From: Bradley Gasawski <bradley.gasawski@co.kittitas.wa.us>
Sent: Friday, January 9, 2026 8:37:42 AM
To: chrisimmer islandchapel.net <chrisimmer@islandchapel.net>; Ed Sewall <esewall@sewallwc.com>
Cc: Jamey Ayling <jamey.ayling@co.kittitas.wa.us>; Bradley Gasawski <bradley.gasawski@co.kittitas.wa.us>
Subject: RU-25-00001 Immer - Square Footage Impact of Wetland

Bradley Gasawski | Planner I

Kittitas County Community Development Services | 411 N. Ruby St; Suite 2 | Ellensburg, WA 98926
Office: 509.962.7539

**MITIGATION SITE PLAN, NOTES, & DETAILS**

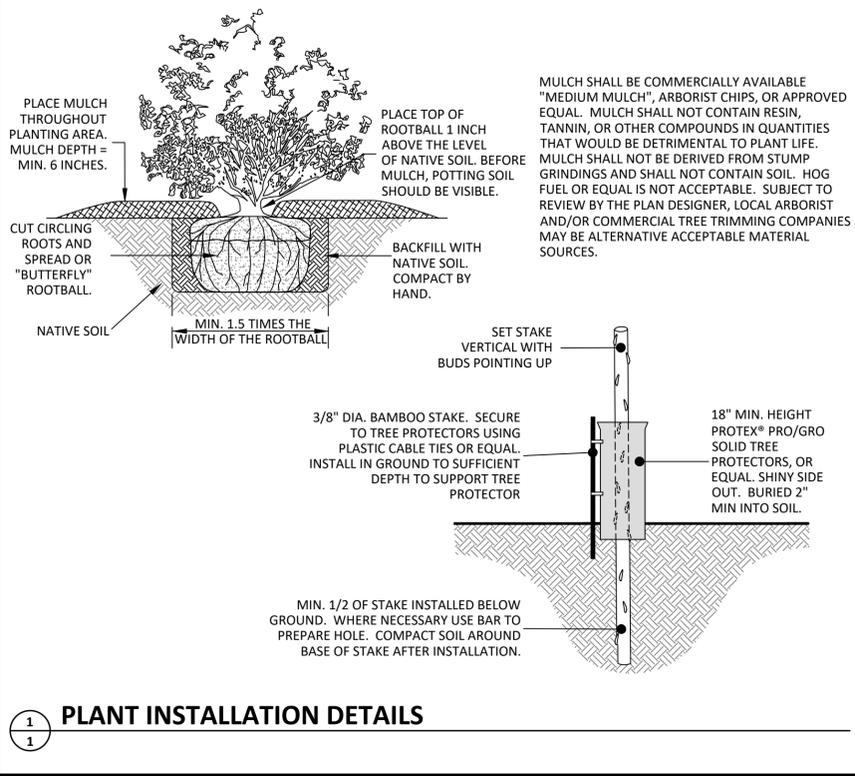
We are working on it today. We will be adding buffer enhancement area in the wetland buffer to compensate for the wetland buffer impacts.

I wanted to follow up with on the request for the square footage impact of the accessory building on the wetland buffer. I've added a pdf I marked up with a blue hatched polygon. This polygon represents the shops area of impact within the wetland buffer. This is the area we are wanting the square foot number. Thanks.

Chris, take a look at the revised plan so you can see what's proposed. This covers the stream and wetland buffer impacts.
